From: Colin Sharpe
Sent: 23 December 2011 11:46
To: Jane Tucker
Subject: FW: Planning Application: 3/2011/0919

SLAIDBURN & EASINGTON PARISH

Re: Planning Application Number: 3/2010/0919

North Elevation

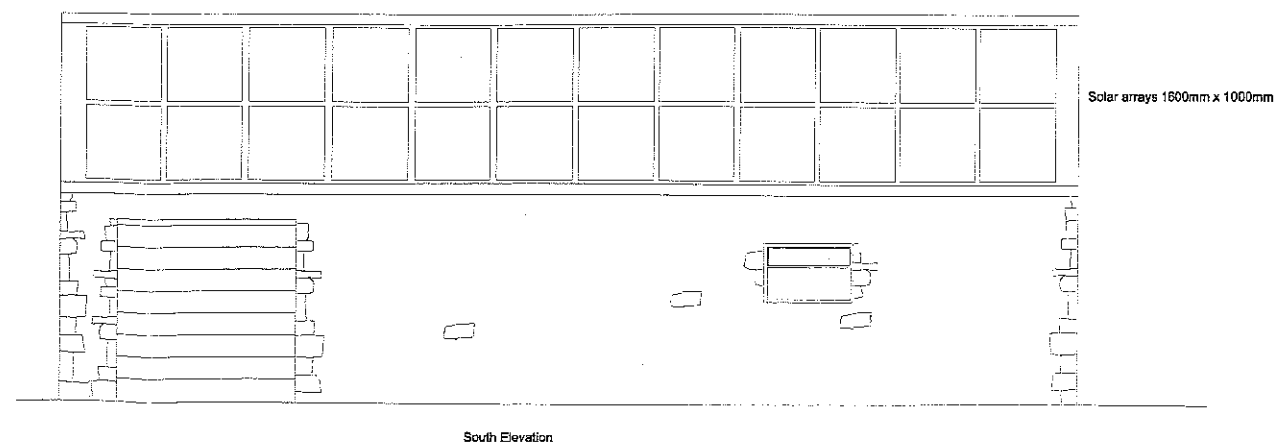
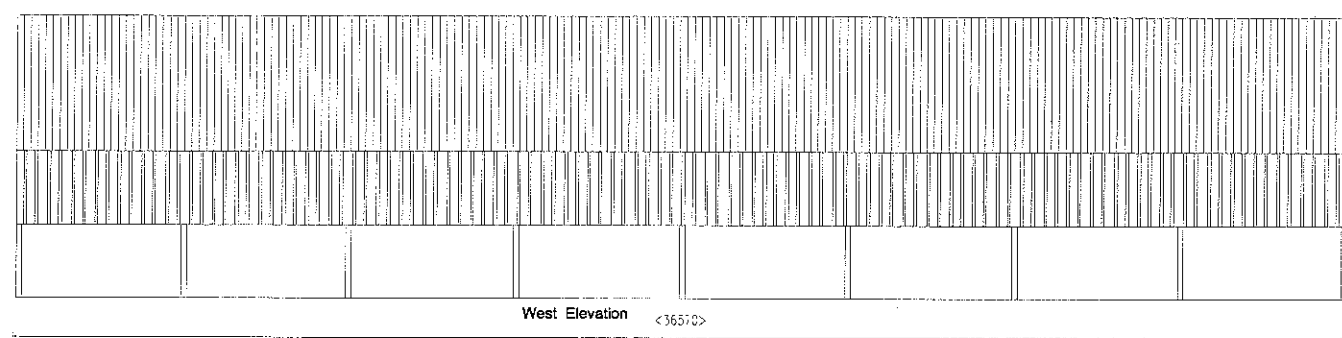
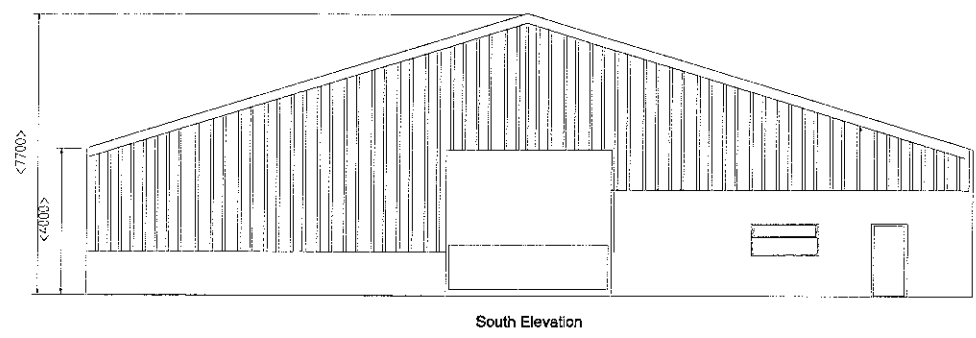
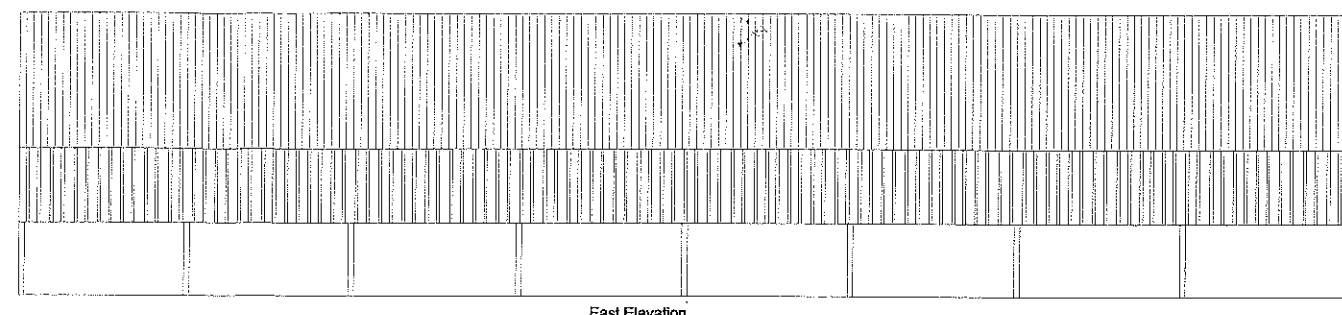
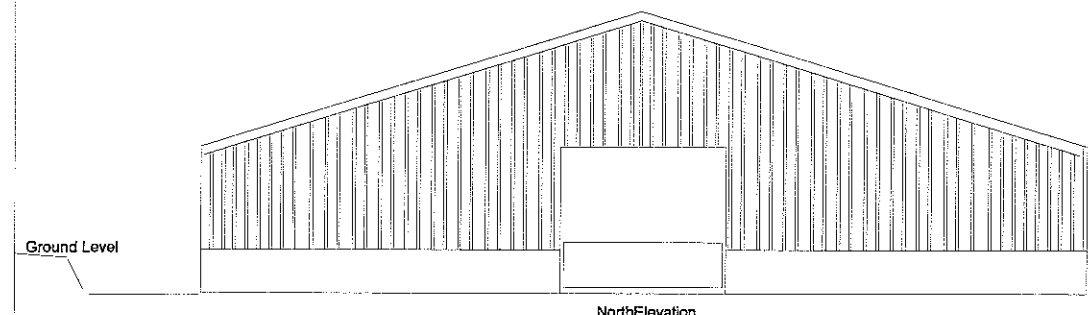
1. Has the pollution risk been fully assessed?
2. Should the planning application be successful, how many personnel are they planning to employ?
3. Is there a stipulation for the Pressing Plant to be stone clad on all sides? If not, then they would wish to make this recommendation.
